From: Jonathan Best <Jonathan.Best@arun.gov.uk>
Sent: 30 January 2026 14:41
To: Planning.Responses <Planning.Responses@arun.gov.uk>
Cc: Jessica Riches <Jessica.Riches@arun.gov.uk>
Subject: A/2/26/DOC

Land north of Water Lane Angmering BN16 4EJ.

I have reviewed Approval of details reserved by condition imposed under reference A/88/24/S73 relating to condition number 6-height, width, and landscaping details of bund along norther n boundary with A27.

All dimensions to be checked on site		
Client		
CALA (South Home Counties) Ltd		
Project		
Land North of Water Lane, Angmering		
Drawing		
Soft Landscape Plan - Bund		
Sheet 5 of 5		
Date	Drawing No.	Rev.
11.01.21	HBA-875-2109	A
File location:		
P:\875 - Waterlane\Drawings\HBA\Current Drawings

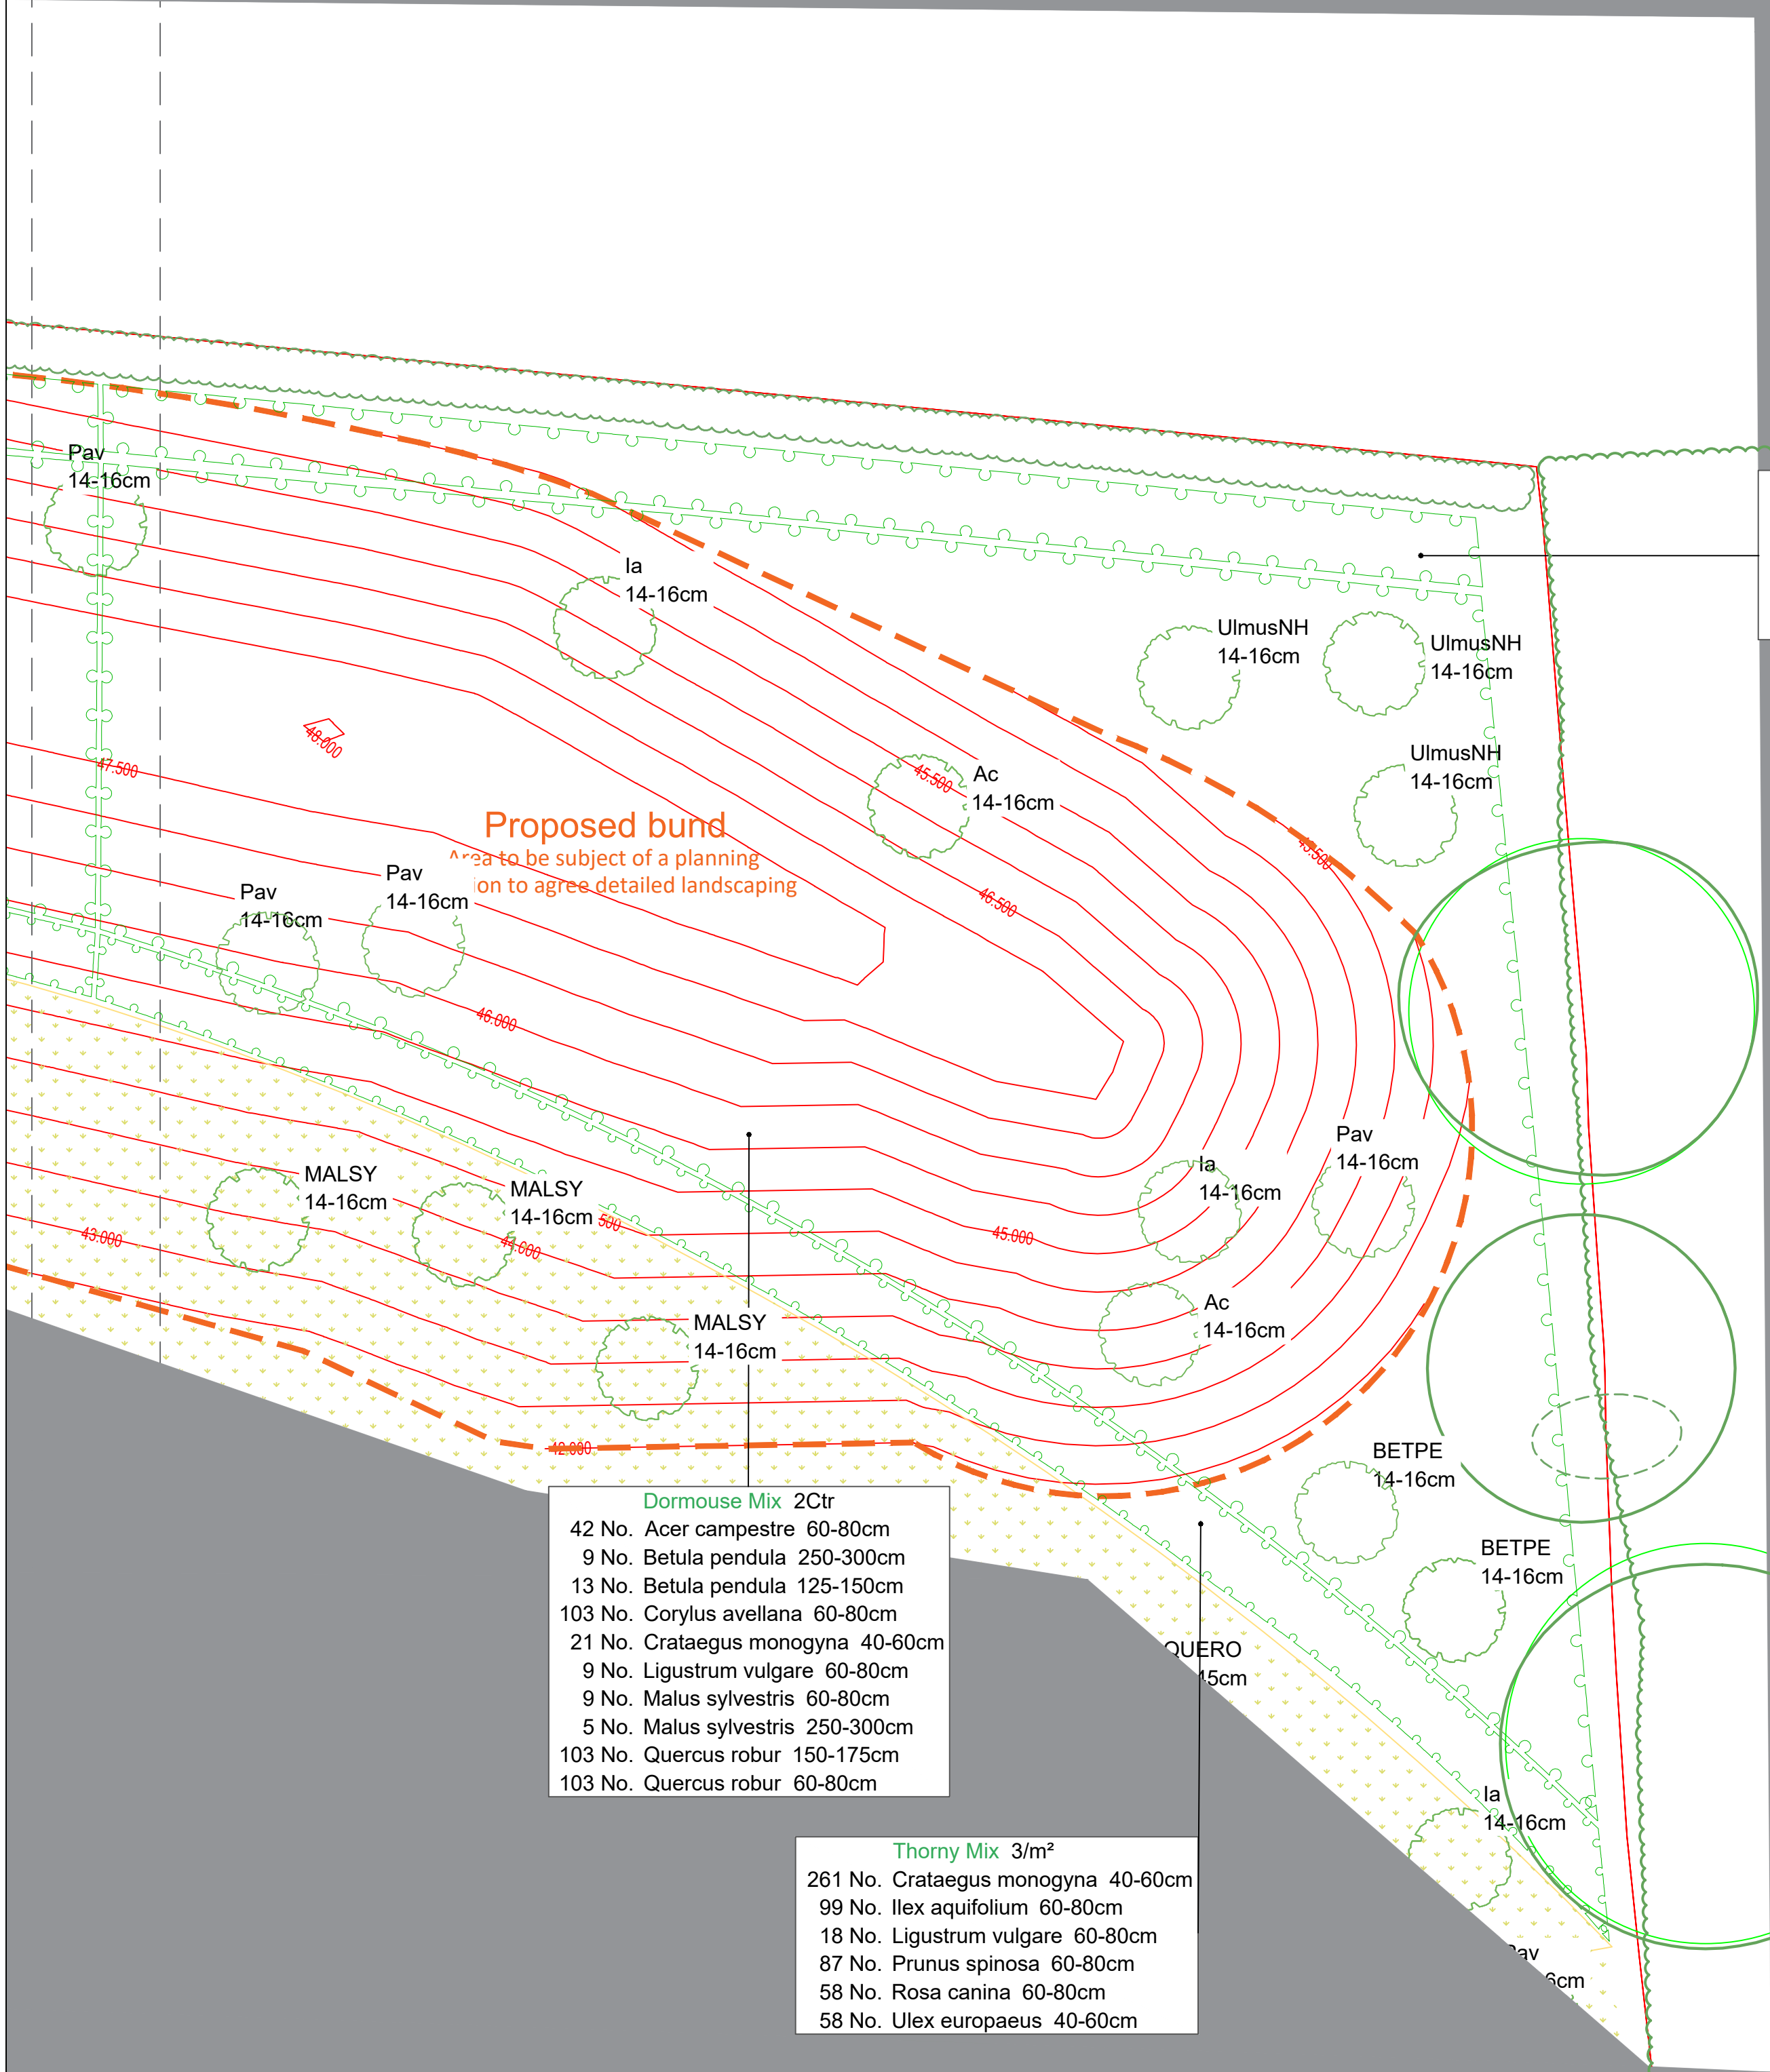
I read the comments from Angmering Parish Council regarding conifers and suggest the inclusion of Yew as this species meets both requirements.

It is fast growing, evergreen and beneficial for dormice. Research has shown the fruits of Yew are a favoured food and dormice will make special excursions to reach them, but the seeds are not eaten.

Little is known about the use made of conifer trees by dormice, but they often support many aphids and caterpillars – potential dormouse food. The trees may also provide shelter from the wind and rain in exposed sites.
